Please ask for: Sian Eggington
Email: sian.eggington@terraquest.co.uk
Telephone: 0121 2341390
Our Ref: BN/69/20/HH
Your Ref:
Date: 10th July 2020

Application for Planning Permission for Works or Extension to a Dwelling

Development: Demolition of existing garage and construction of new garage
Location: Ravenhurst Church Lane Barnham PO22 0DG

Block Plan (Extract from Ordnance Survey)

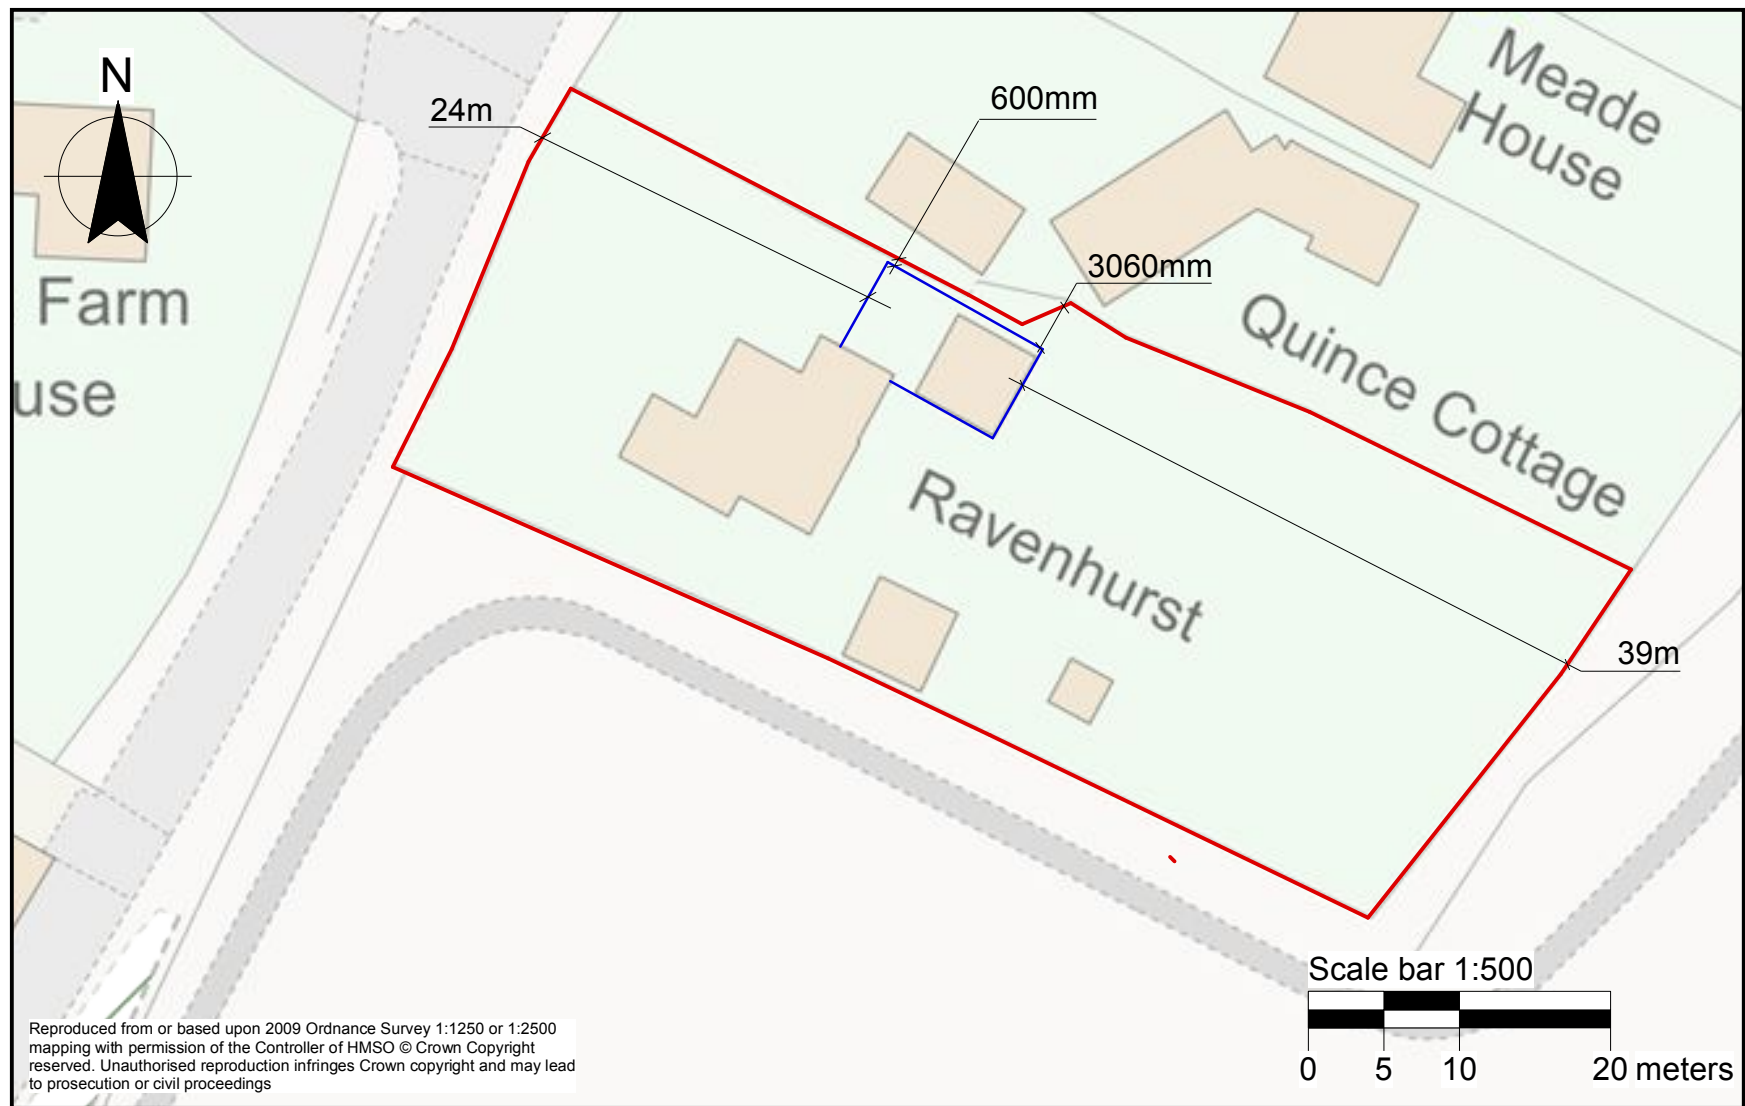
Block Plan

You are required to have clear dimensions from the proposed extension(s) to all site boundaries. The dimensions you have provided are unclear. Please amend.
